From: Simon Davis
Sent: 01 July 2021 12:29
To: 'Lauren Wiltshire' [REDACTED]
Subject: RE: Fontwell Avenue, Eastergate

Condition Refusal Issued 29/06

Forthcoming Condition Refusals to be issued today/tomorrow

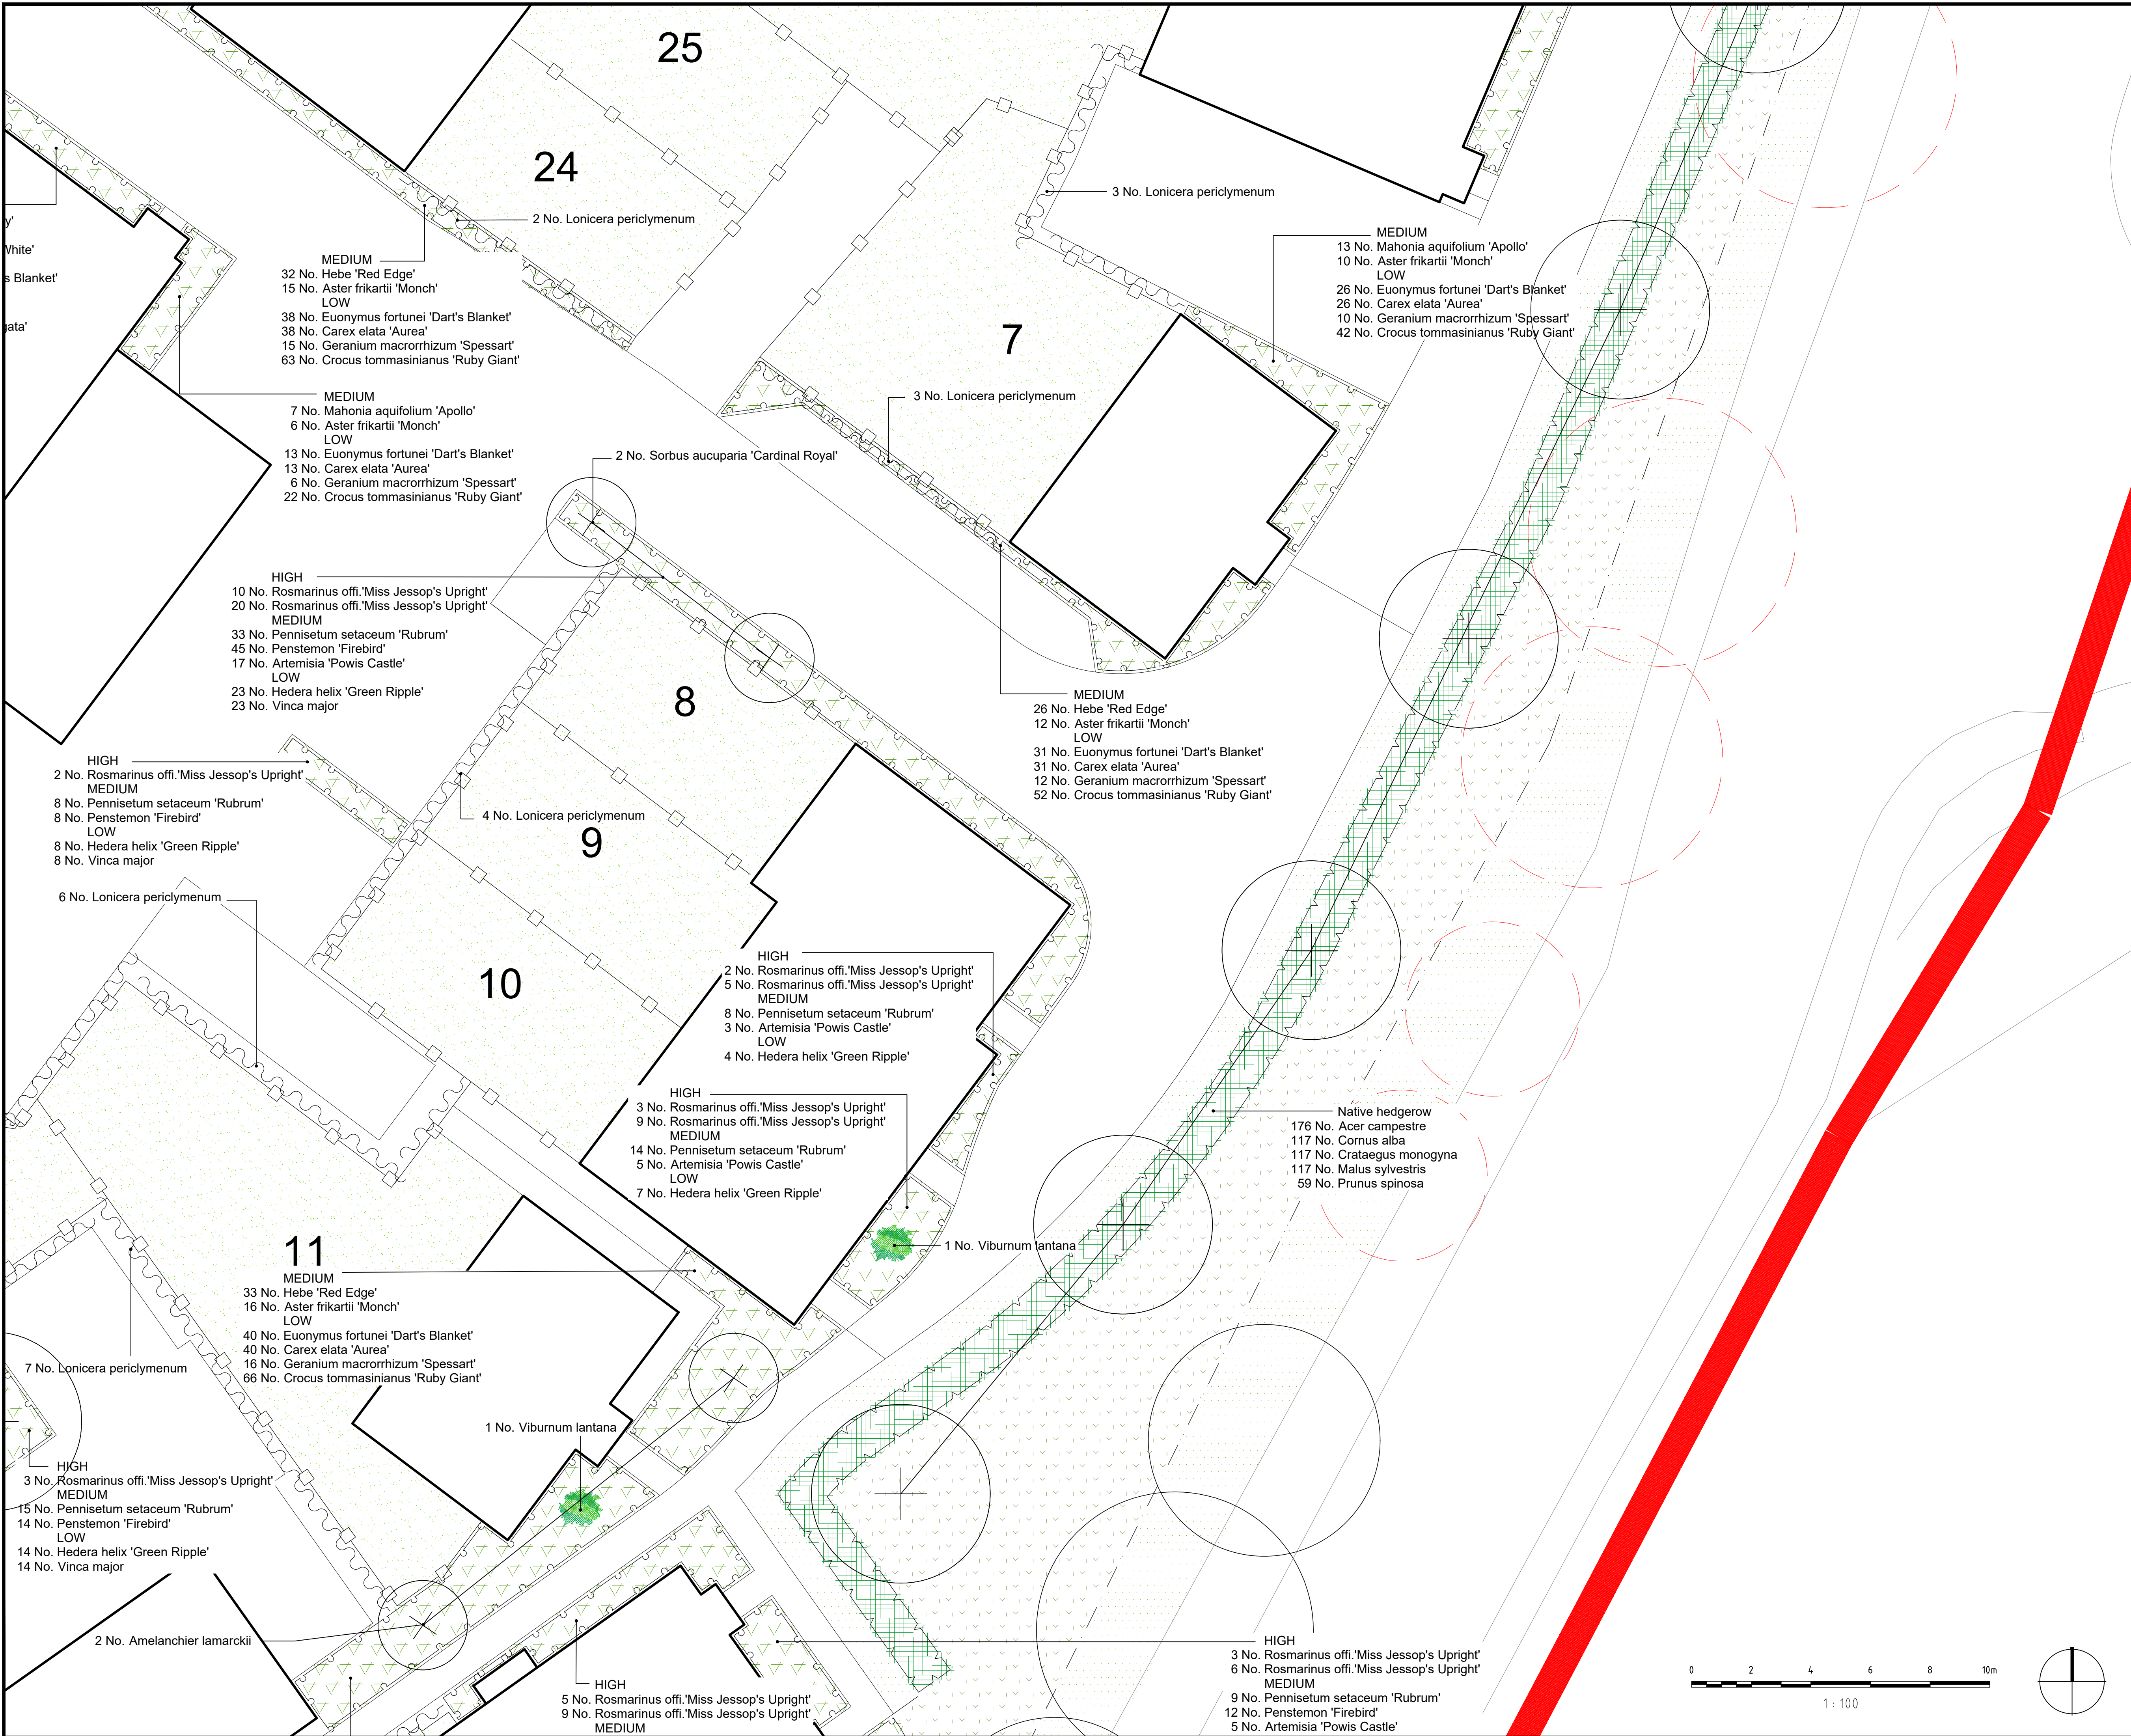
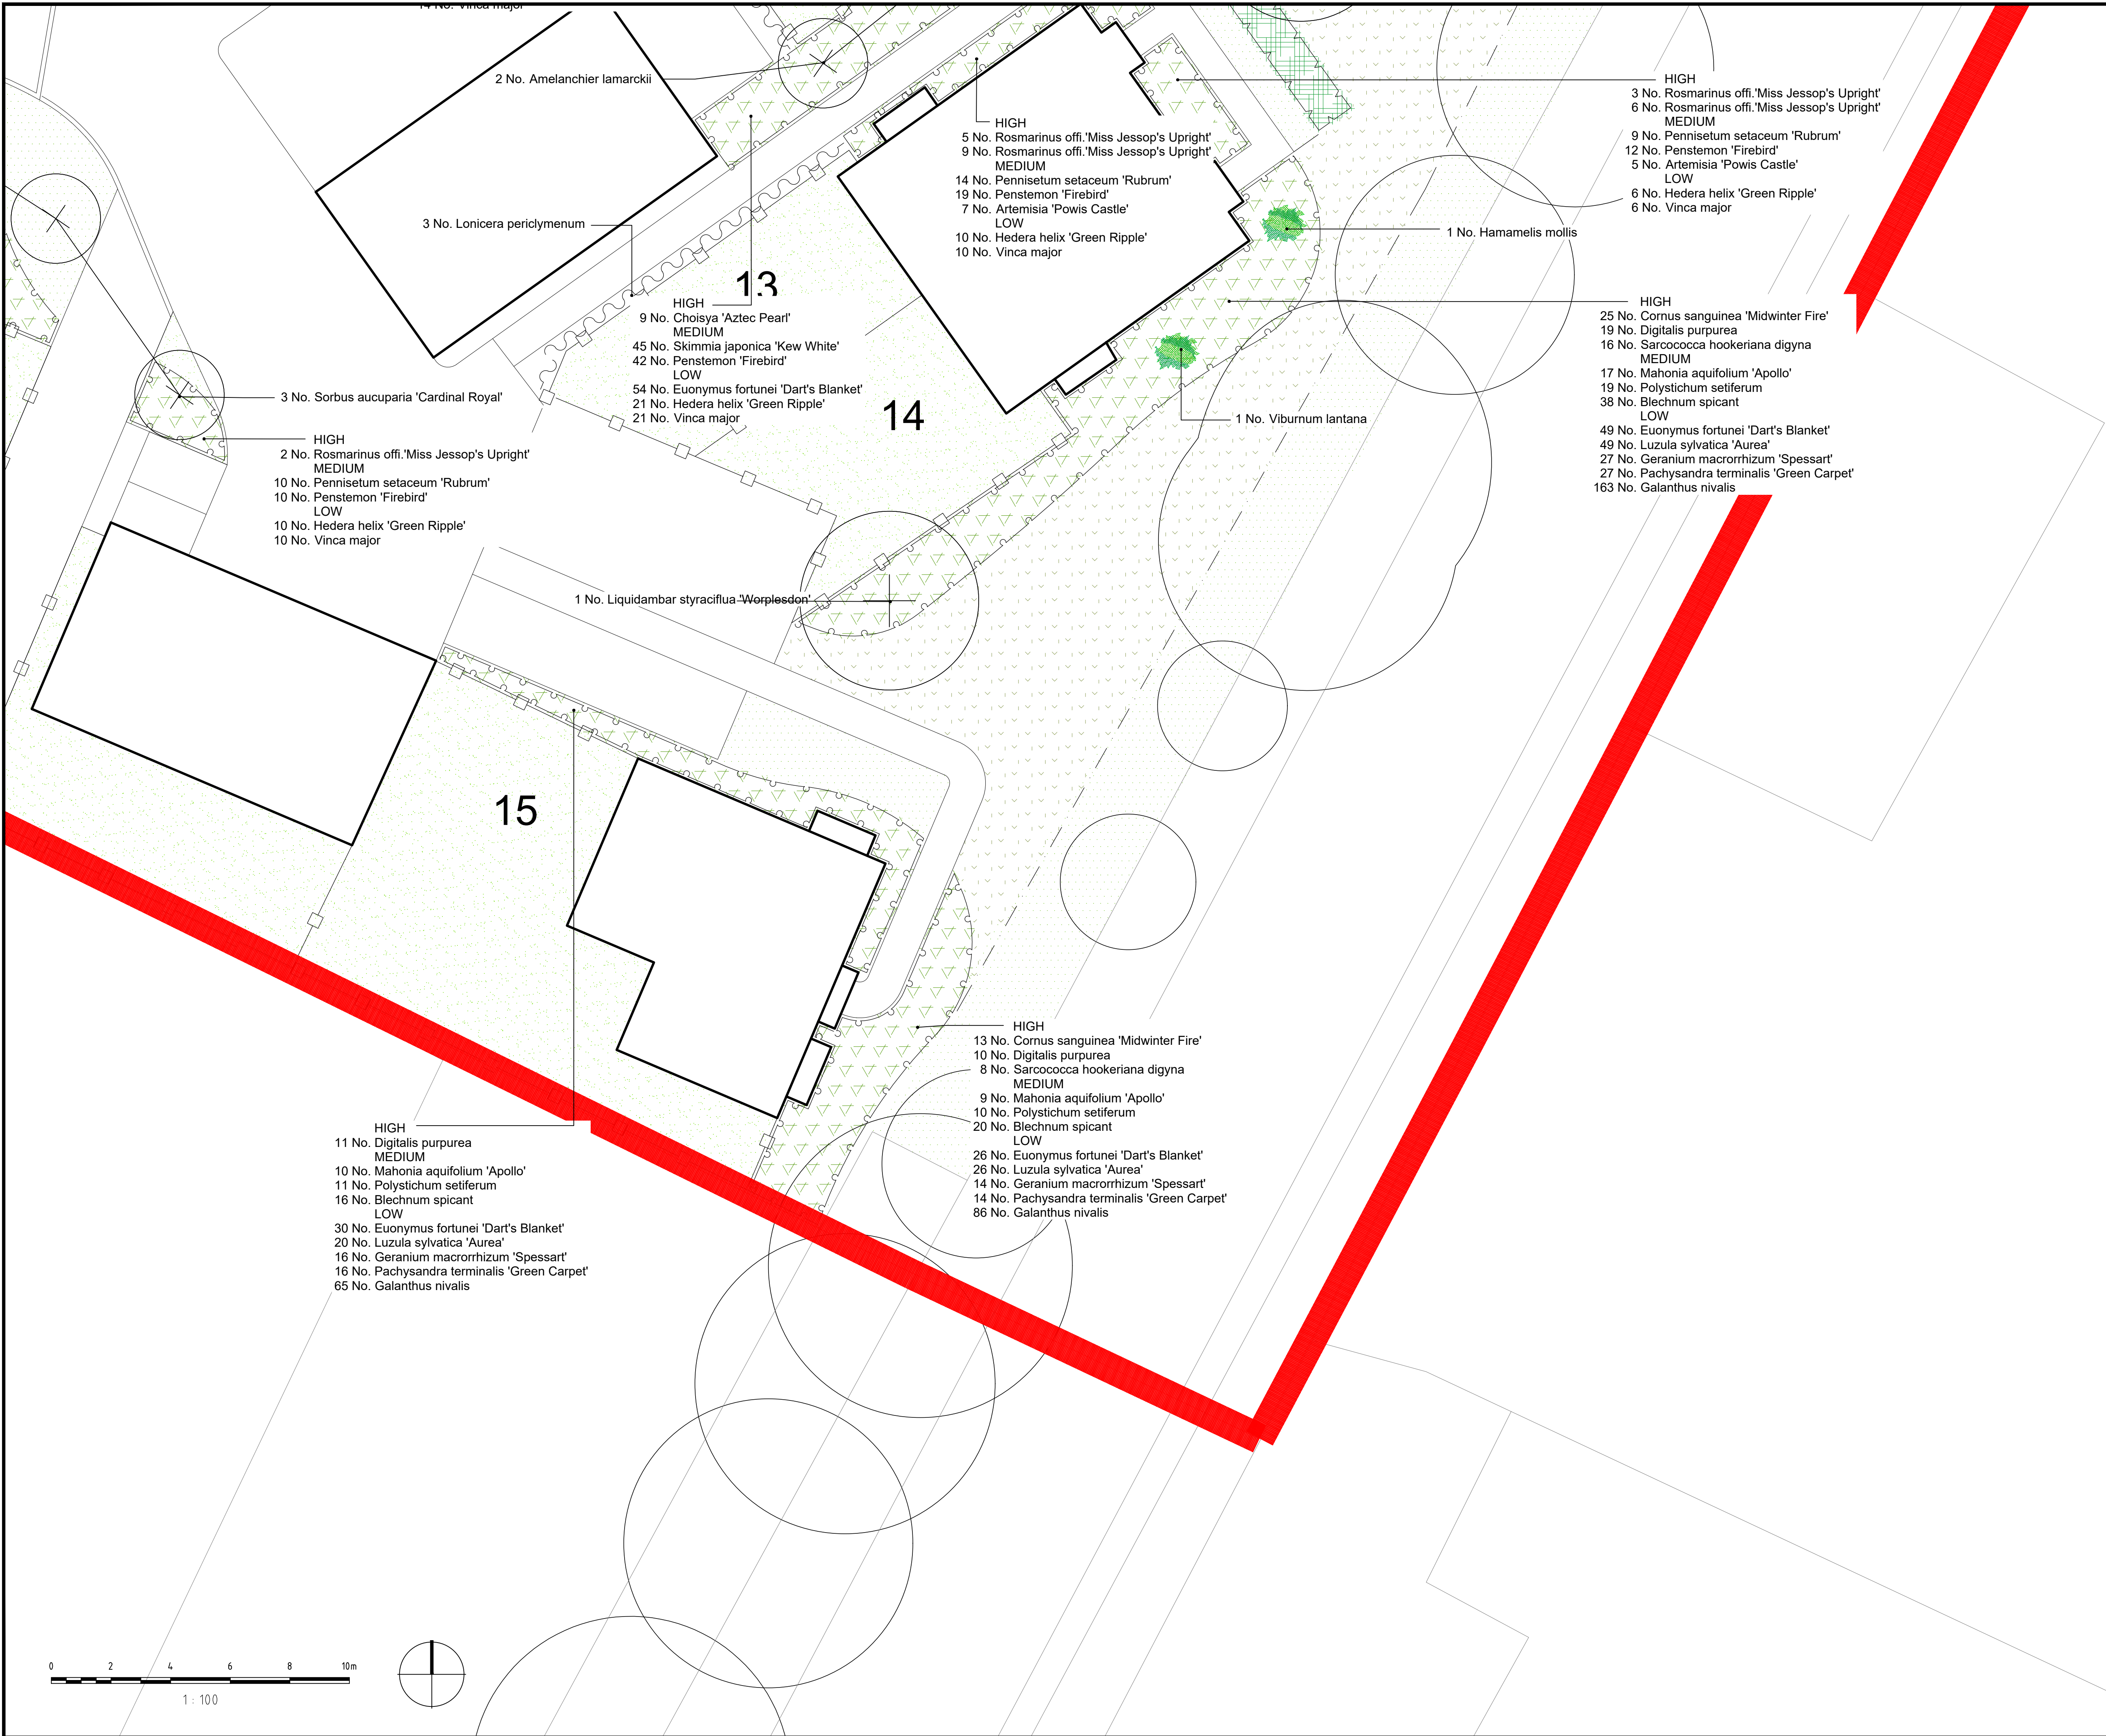
17 – Our Landscape Officer, Sue Howell requested that the play area details be shown on the drawings. Her comments were sent to you on 07/06/21. However, it was I who picked up on the fact that the non-standard requirements of the condition (26 new native trees inc large specimens) had not been clearly addressed.
